Recommendation Report for Planning Permission for Works or Extension to a Dwelling

REF NO: EG/15/19/HH

LOCATION: 5 Critchmere Road
Eastergate
PO20 3XA

PROPOSAL: Retention of conservatory & flue.

Roof profile + ground floor plan 1:100 @ A4
 Drg no. 02

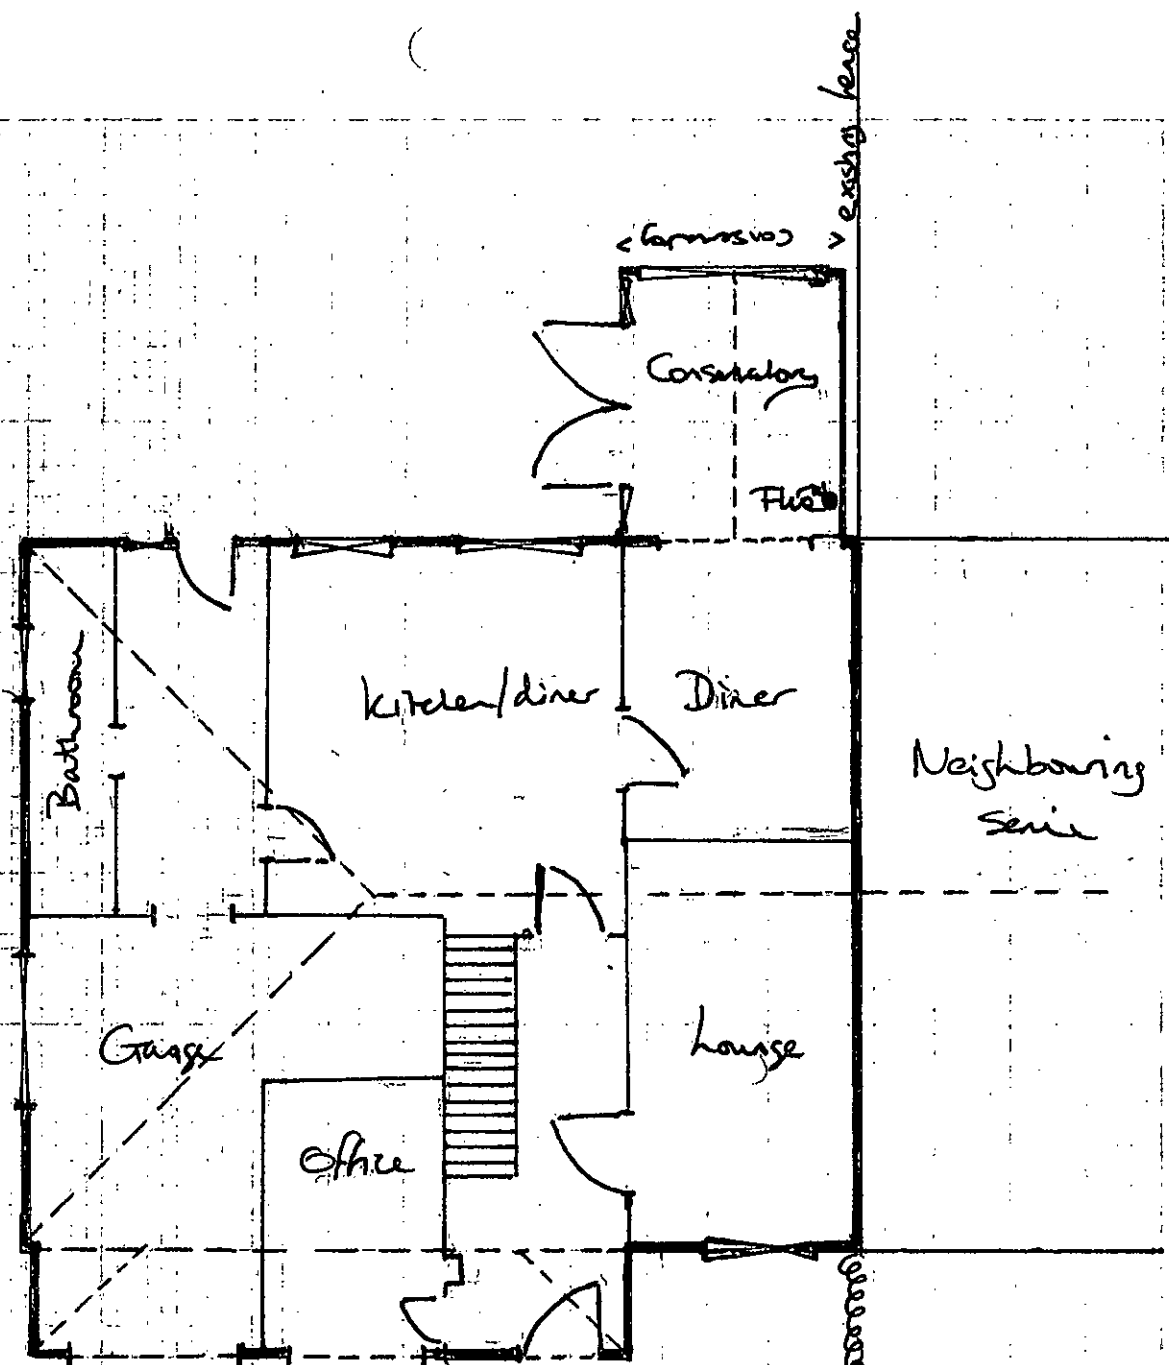
The conservatory is constructed to a depth of 3.6m and a height of 3.10m. It is situated close to the boundary to the north, however the conservatory is only around 0.6m larger in depth than that which could be constructed without permission as a result it is not considered to give rise to any adverse overbearing or overshadowing upon neighbouring amenity.

The flue extends from the conservatory and runs along the rear wall of the property with a height approximately 1.6m above the eaves and 1.65m below that of the ridge height of the host dwelling. Whilst this is positioned close to the neighbouring property and is quite high the size would ordinarily fall under permitted development. In this case as it is connected to the conservatory which requires

At its current siting and height, it cannot be argued that any impacts upon residential amenity are significant in which a refusal is justified.
